From: Stewart Morris [REDACTED]
Sent: 05 July 2019 15:37
To: Simon Davis <Simon.Davis@arun.gov.uk>
[REDACTED]
Subject: RE: FP/57/19/PL Residential Conversion of Ye Olde Malt House Restaurant

Conservation Officer Response

FP/57/19/PL

The application is for the conversion of the existing restaurant (A3 Food & Drink) & flat into 2 cottages, including the alteration of the principal elevation at ground floor level. This will involve the loss of the shop front.

EXISTING FRONT ELEVATION

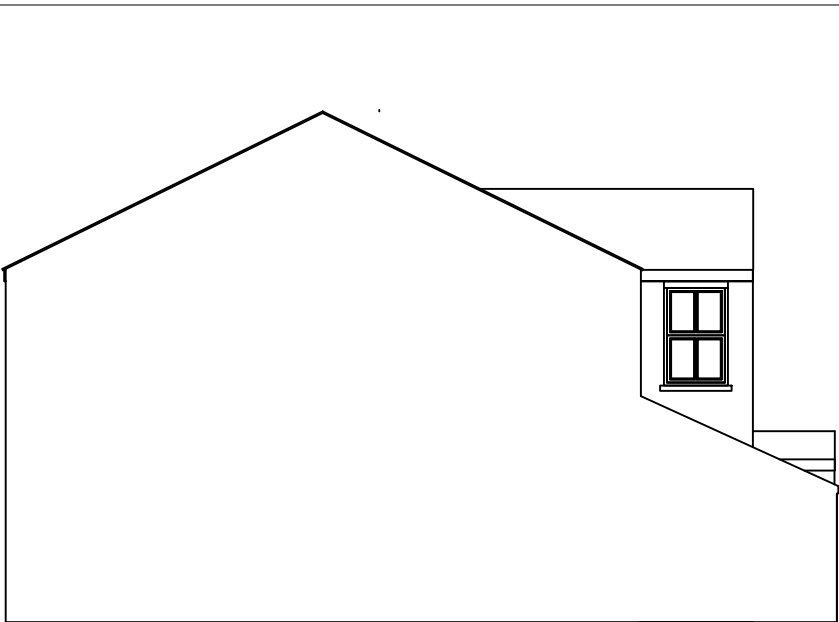
Furthermore, it is unfortunate that the existing shop front is to be removed, as it would result in the loss of an attractive feature on the street-scene, as well as a reference point to a previous use. If the shop front is to be removed, the replacement elevation should reflect the building in the local area.

PROPOSED GROUND FLOOR

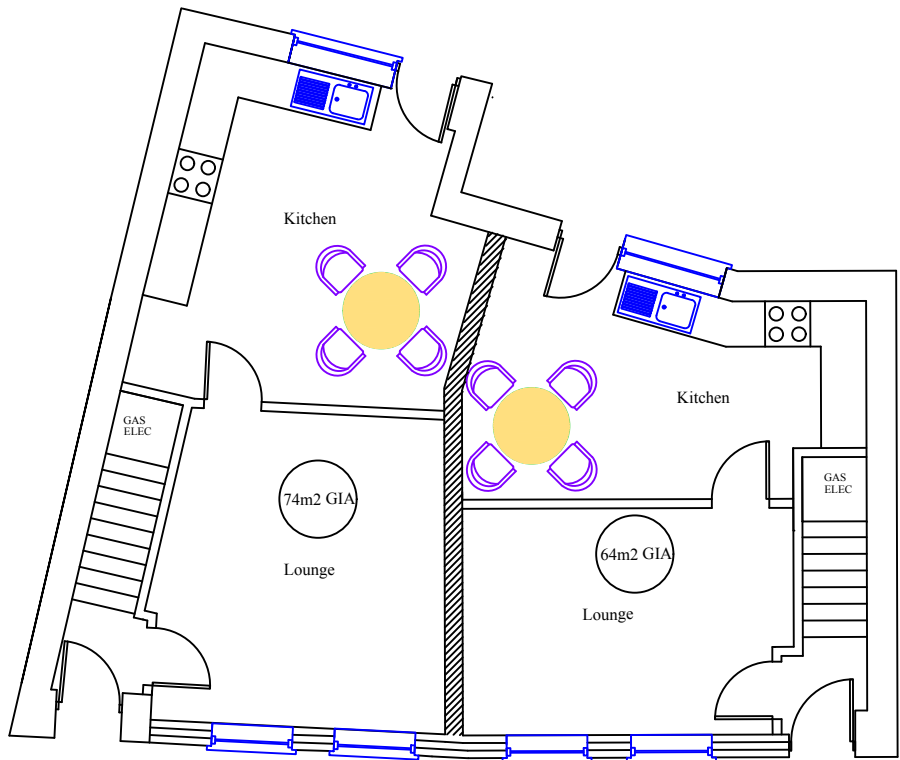
Having reviewed the plans it is not clear why the current fenestration pattern has been proposed as it has been. The provision of a second window on the ground floor (front elevation) is in conflict with the established character of the properties in the immediate surroundings; at present these neighbouring properties consists of one window over another one.

- Remove one window from the ground floor front elevation
- Provide specification for alternative front doors to front elevation.
